**From:** Pendleton Parish Clerk <clerk@pendletonvillage.co.uk>  
**Sent:** 17 April 2020 14:14  
**To:** planning  
**Cc:** rwhitwell1976@yahoo.co.uk; gjwhitwell@gmail.com  
**Subject:** Planning Application 3/2020/0142 - Golf Club

Pendleton Parish Council would state as follows in connection with the above:

CLATHEROE G.C.
 PROPOSED DRIVING RANGE SHELTER + TRAINING ROOM
 SITE PLAN
 1:1050 JULY 2011 DNI
 spa
 BINGELAND PRACOCK ARCHITECTS
 9825 - 1-6

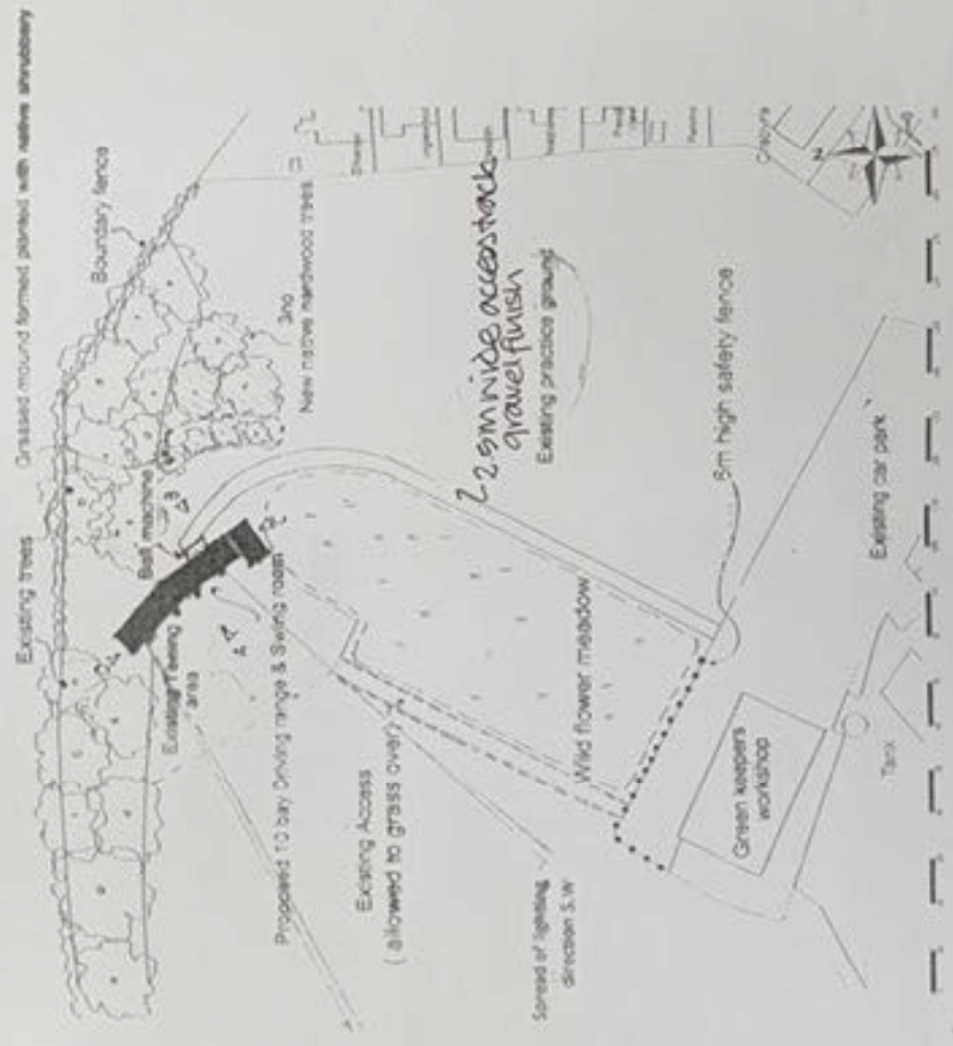
1. The project should have some landscaping behind the proposed building, of high growing trees to hide the driving range from the homes at the top of Whalley Rd.
2. The original low level lighting is more appropriate, and the original times of 8am-8pm be reinstated, due to the close proximity of these properties.
3. It would be appropriate on this occasion for the application to be looked at by committee.
